PROJECT NAME:
**RCH VALLEY
875 VALLEY STREET
RCH VALLEY SITE/DEMO LITION PLAN**

DRAWING TITLE:
RCH VALLEY SITE/DEMO LITION PLAN

SHEET:
C-1

PCD File # COM246

SHEET:
C-1

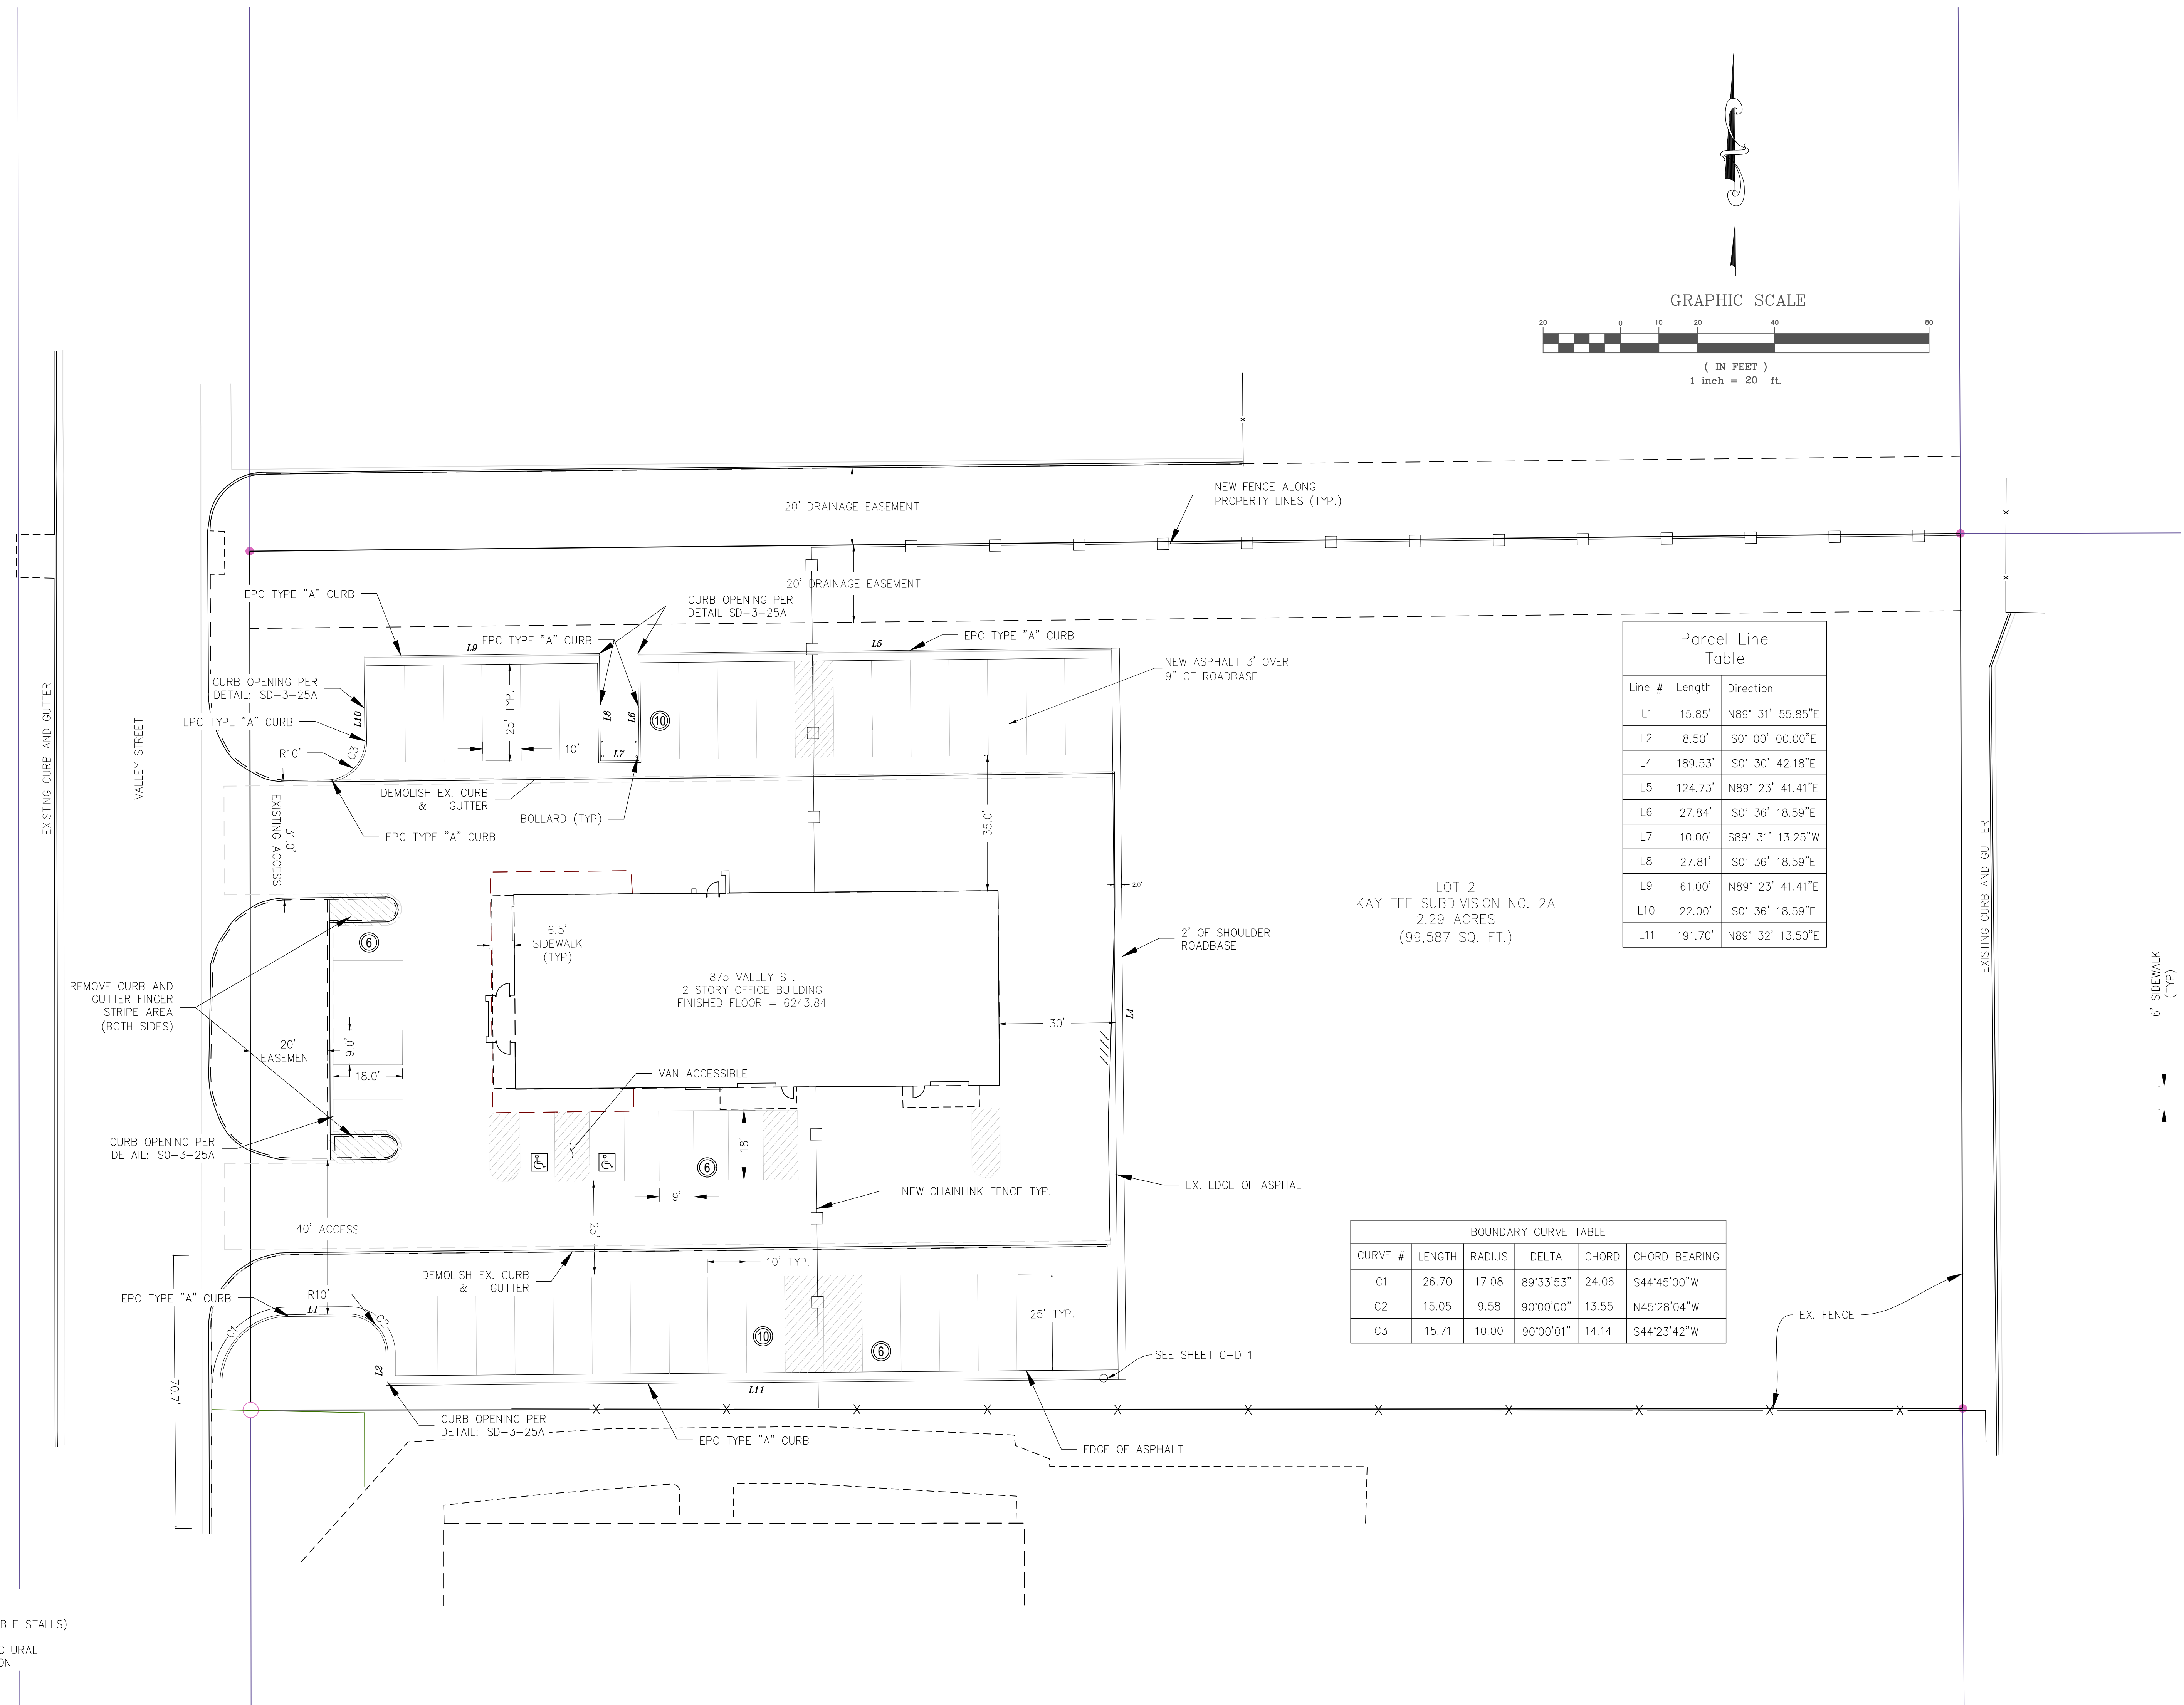
The following note should be added to all site development plans or non-residential site plans, as applicable, prior to PCD approval:
The parties responsible for this plan have familiarized themselves with all current accessibility criteria and specifications and the proposed plan reflects all site elements required by the applicable ADA design standards and guidelines as published by the United States Department of Justice. Approval of this plan by El Paso County does not assure compliance with the ADA or any regulations or guidelines enacted or promulgated under or with respect to such laws.

Add the following to site development plan:
- Vicinity Map
- Signature block the Planning and Community Development Director a minimum of 1 inch by 2 inches
- Location and dimensions of all existing and proposed signage on site
- Location of all garbage receptacles with a graphical depiction of the screening mechanism
